From: Simon Davis
Sent: 05 April 2022 10:12
To: Julian Evans [REDACTED]
Cc: 'Miles Hamilton' [REDACTED]
Subject: RE: Topo at Sefter Road ,Pagaham,PO21 3EE

RE: P/15/22/DOC – Sefter Road

Subject: RE: Topo at Sefter Road ,Pagaham,PO21 3EE

title: Topographic Survey scale: 1:250@A0

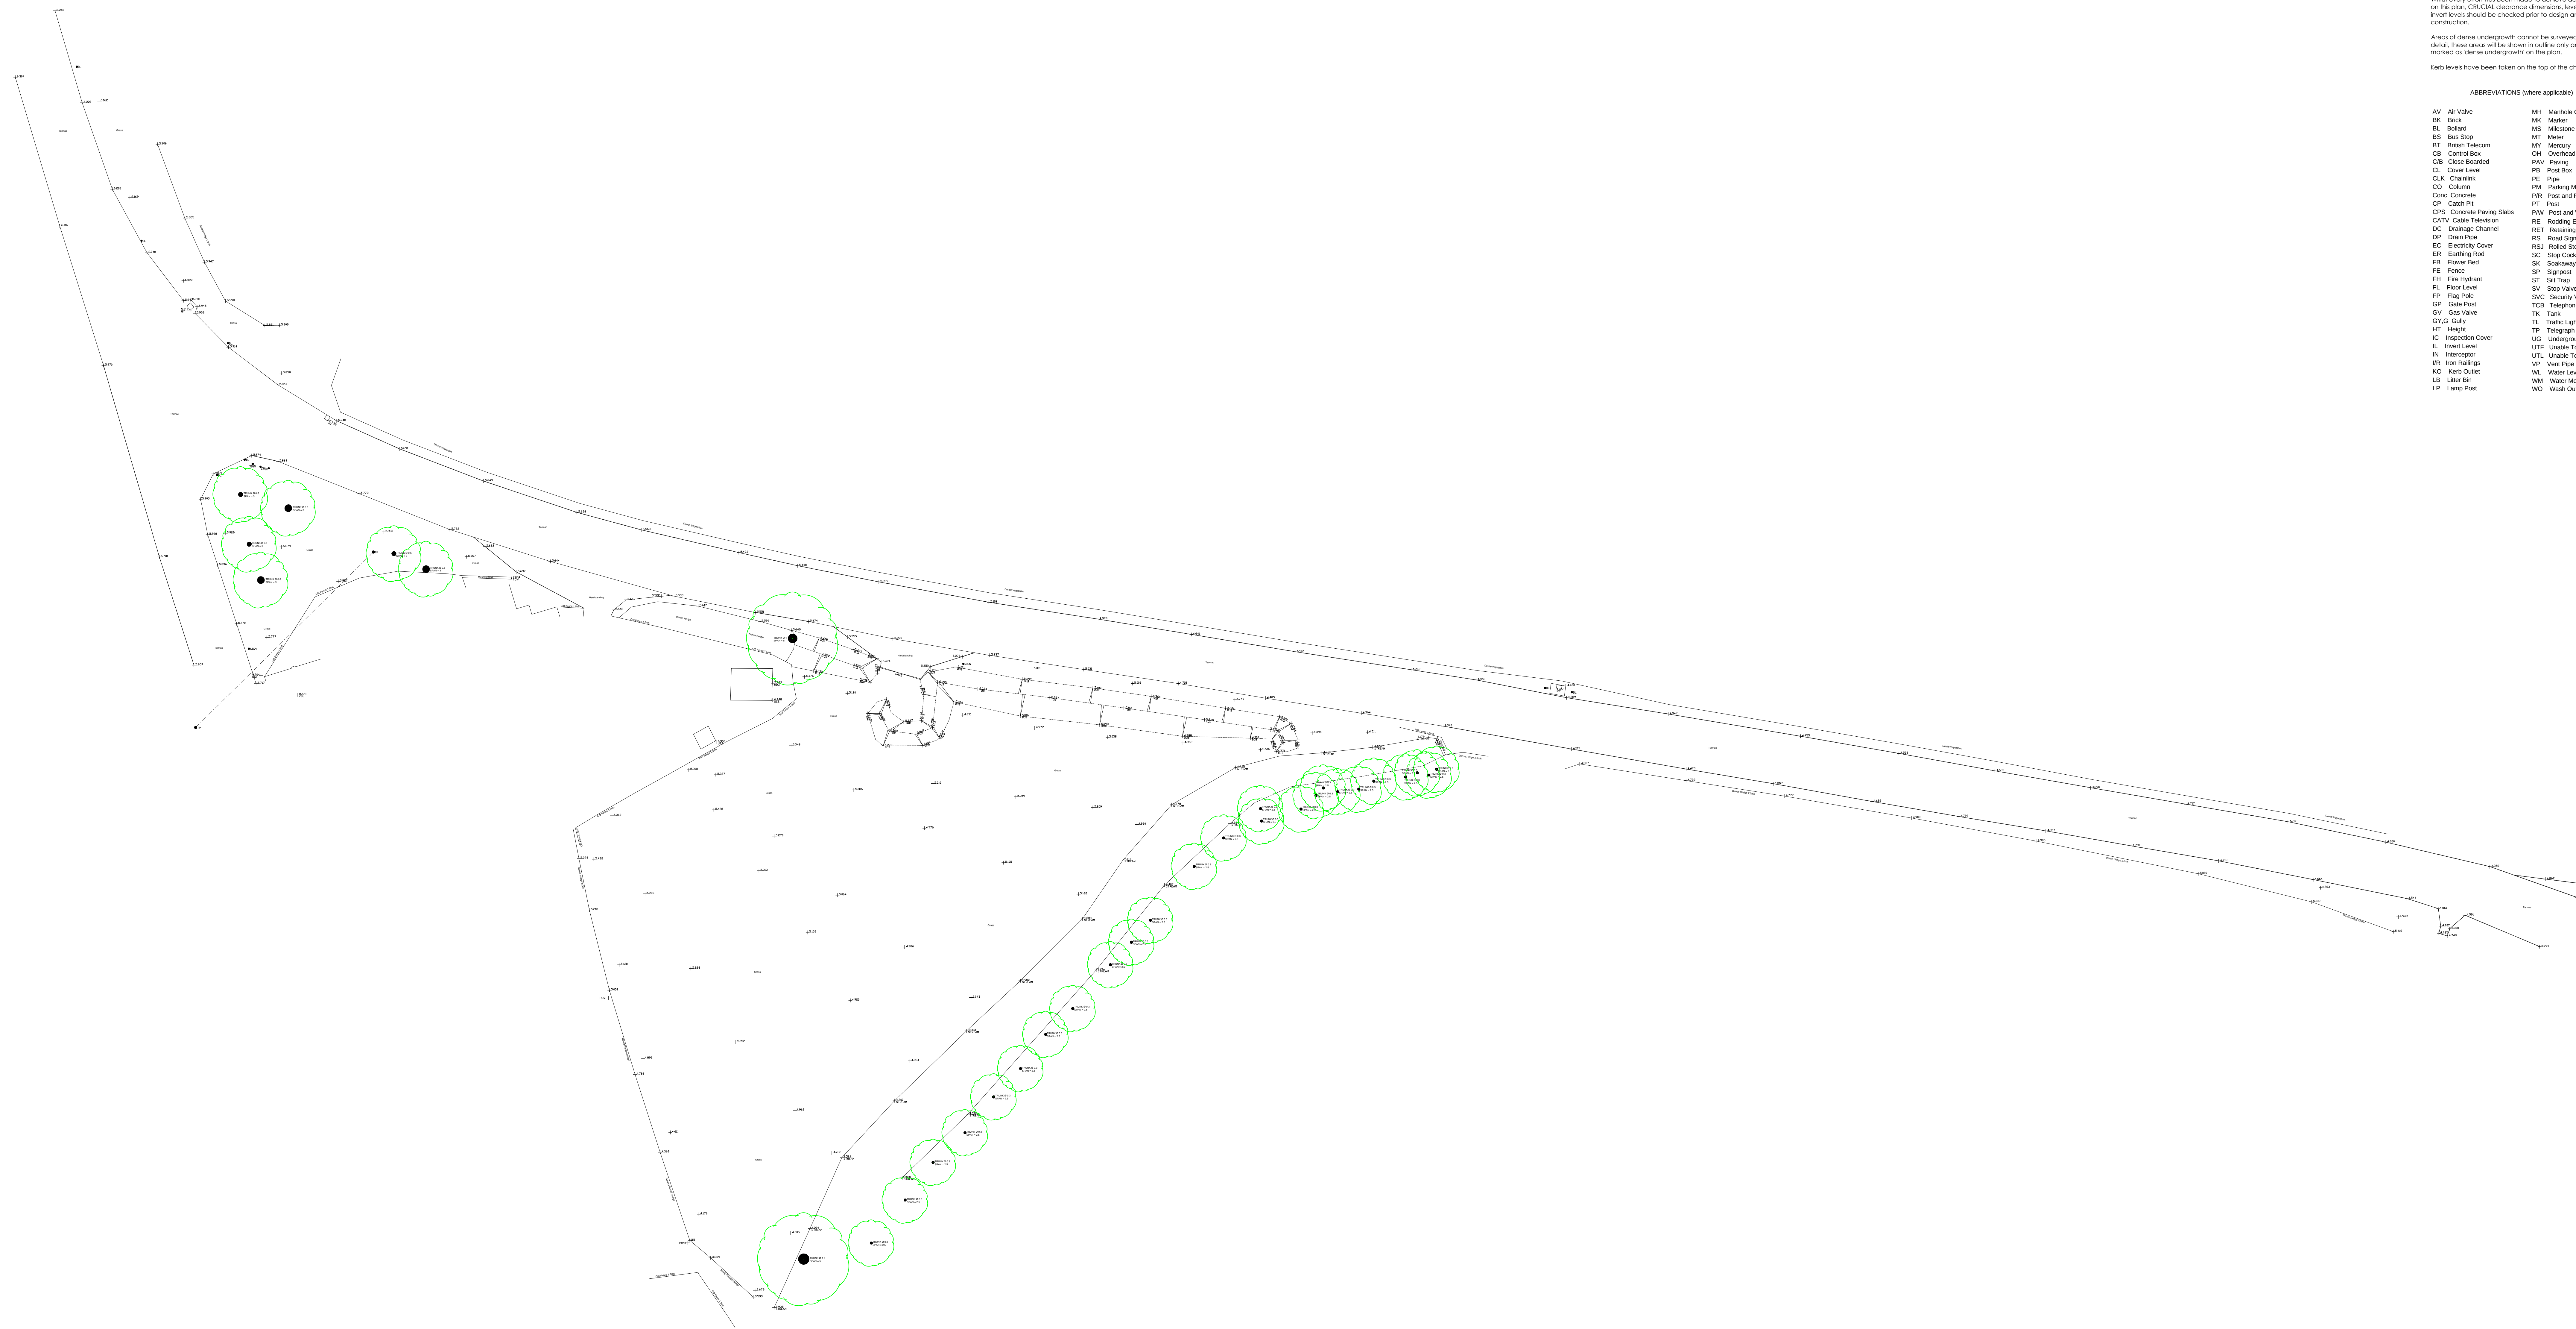
'We note that the levels of the ditch are shown to drop away sharply nearly the point of proposed connection. Please check all ditch levels on site. Please also provide downstream culvert invert levels, as well as soft and hard bed levels of the watercourse. An extended outfall pipe is proposed to get the discharge to the area where the watercourse is deeper. However, it may be that soft bed levels are shown upstream and that a discharge point closer to the hydrobrake and drainage features is actually achievable with necessary maintenance completed to the watercourse'. Cadmap conducted a survey of the ditch in March 2022. The updated survey indicates a bank level of 2.95m A.O.D and standing water within the watercourse as 3.09m A.O.D near the proposed hydrobrake control. Connectivity via gravity is feasible at this location and as such the drainage scheme outfalls have been reviewed accordingly. The network model has been reassessed assuming surcharging of the outfall to the top of bank level (circa 4.9m aod). The revised modelling with the surcharged outfall indicates negligible flooding at the pond (approximately 0.383cu.m) for the peak 1 in 100 year storm event with additional 40% allowance for climate change but is viewed that this is within an acceptable limit as there is no risk to surrounding properties or occupants of the development. The Cadmap survey, revised drainage proposals and hydraulic model have can be found within the updated appendix.

As a result of the revised survey and the LLFA consultee comments I now attach an appendix update with the additional information.
